23 October 2020 REF: WTJ19-513

RE: SECTION 4.55(2) MODIFICATION TO SSD 7709 — PROPOSED MOOREBANK INTERMODAL PRECINCT WEST — STAGE 2 — SSD 7709 MOD 1

PROPERTY AT: MOOREBANK AVENUE, MOOREBANK (LOT 1 DP 1197707)

Table 1: Response Matrix

WAREHOUSE 5 ELEVATIONS 1

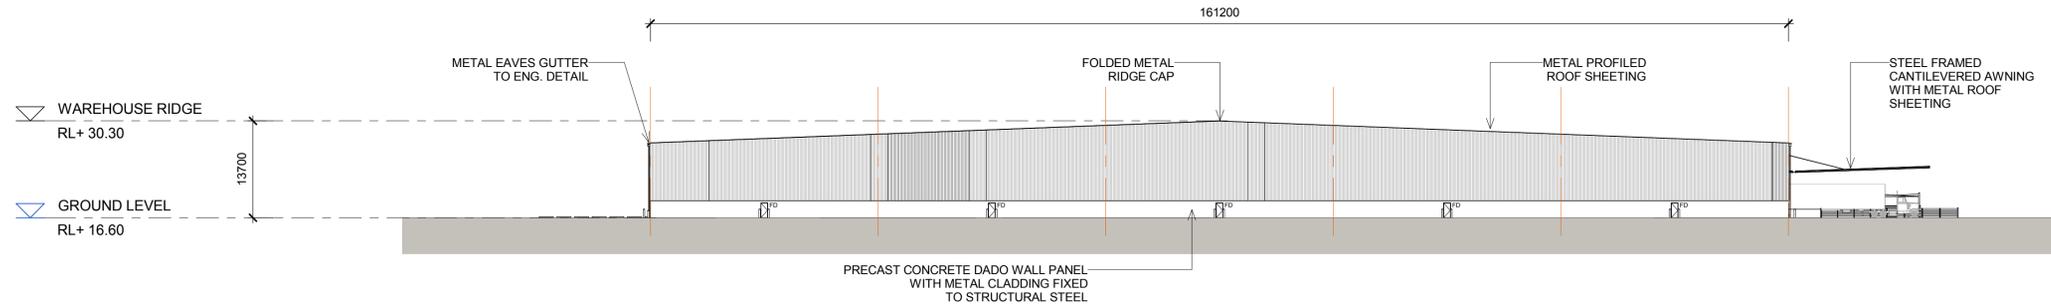
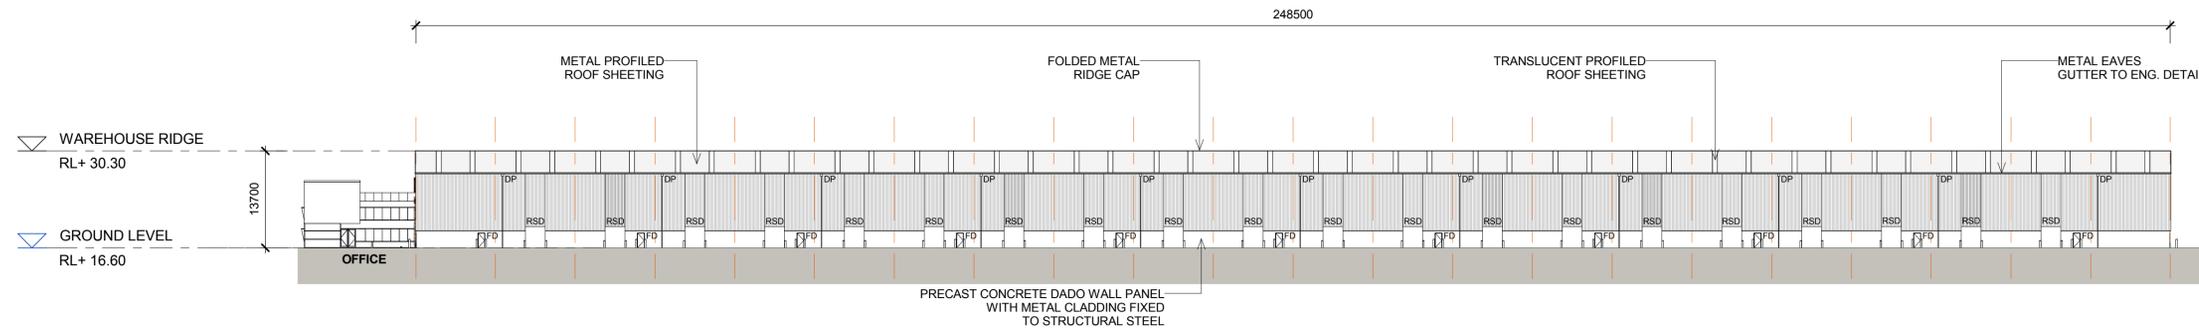
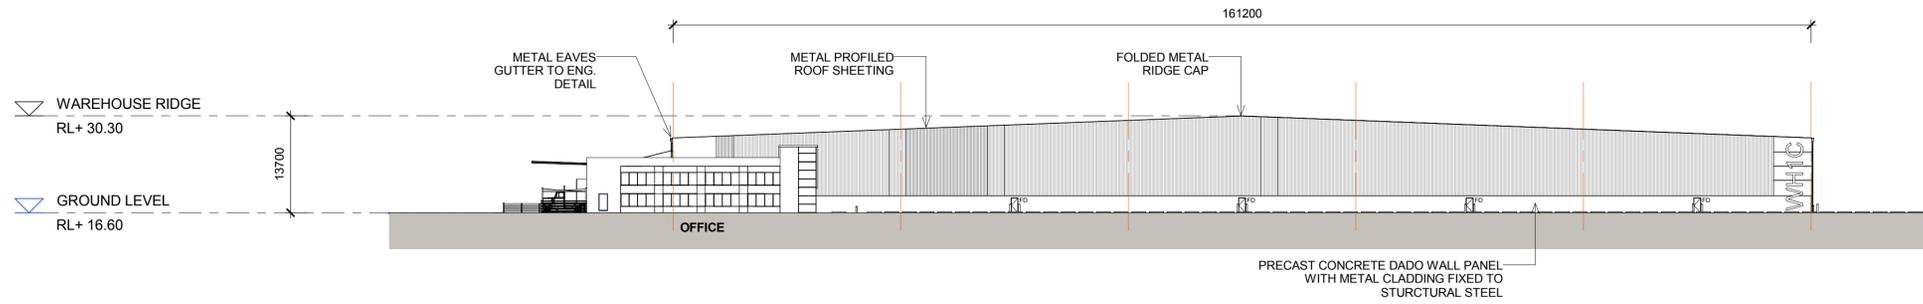
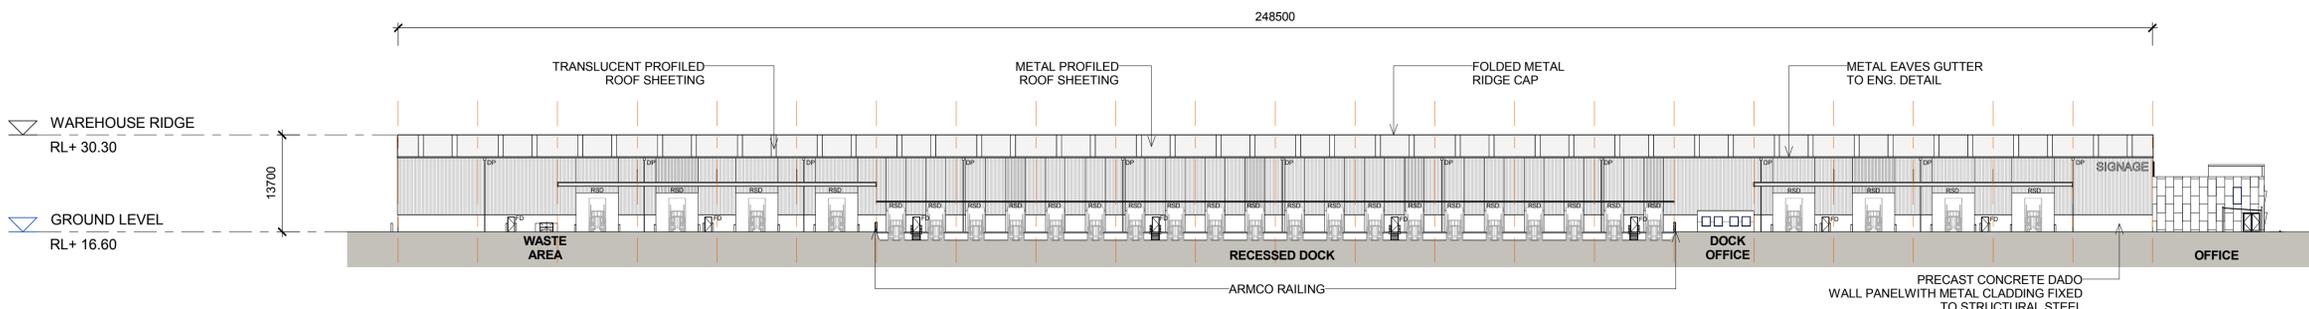
The proposed increase in building heights for warehouses 5 and 6 is a key concern raised during the exhibition of the modifications, which the Department requests you address. Additional information required to address these concerns should include, but not be limited to:

Further justification of the proposed 45 m heights and subsequent non-compliance with the Liverpool LEP;

In response to the submission raised by the NSW DPIE, the height of the highbay component proposed for the JR warehouse has been reduced (from 42.6 m to 39.4 m) to a more appropriate level consistent with the surrounding industrial character articulated within the Moorebank Logistics Park (MPE & MPW), as well as other surrounding industrial developments to the north of the Site.

Whilst a Clause 4.6 Variation request is not formally required as part of a Modification Application, Willowtree Planning prepared the *Clause 4.6 Variation – Height of Buildings (Clause 4.3)* document, which includes significant justification with respect to the proposed 45 m height limit with respect to the future built form pertaining to Warehouses 5 (JR - 39.4 m) and 6 (JN - 43.25 m).

Figure 1 Noise Monitoring Locations

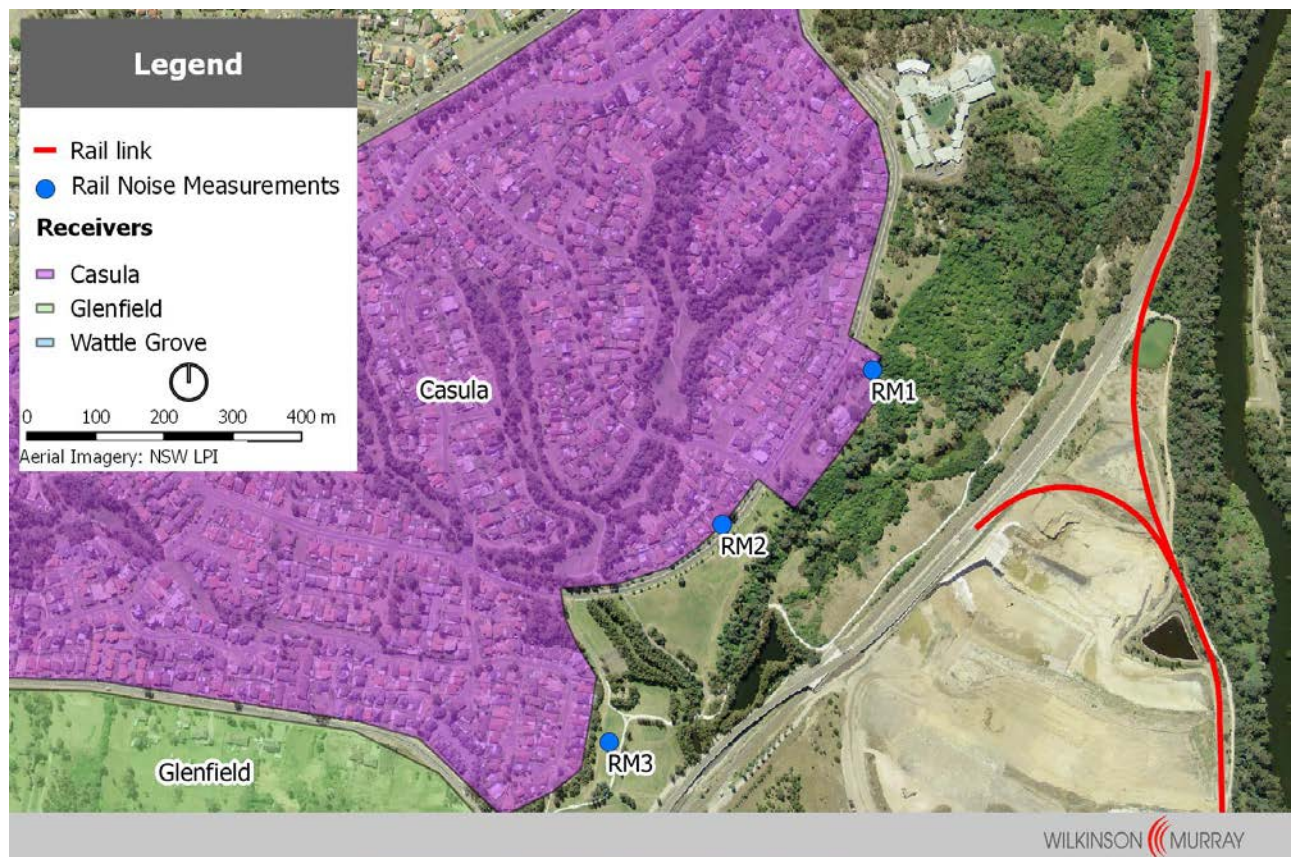
Demonstrate that where all loggers have been placed is "truly representative of the most affected residence" (Noise Policy for Industry); and

The noise survey's that were included in the "Moorebank Intermodal Terminal Precinct - Operational noise management" review for establishing background noise levels were based upon the noise surveys presented in the MPW (SSD 5066) and MPE (SSD 6766) EIS documentation. The locations are detailed in Table 4-1 of "SIMTA Noise Assessment – Concept Plan" (Report No. 12186-C, Version C, Wilkinson Murray, 2 August 2013) for MPE logging data and Table 4 of Moorebank Intermodal Terminal EIS- Noise and Vibration Impact Assessment (Report No. 620.10816, 1 October 2014, Revision 1, SLR) for MPW logging data. This monitoring data and the criteria derived from it has been included in the reports that have been reviewed as part of the project applications by NSW Department of Planning and Environment (DPIE), NSW Planning Assessment Commission, NSW Environment Protection Authority (EPA) and independent reviews on behalf of NSW DPIE.
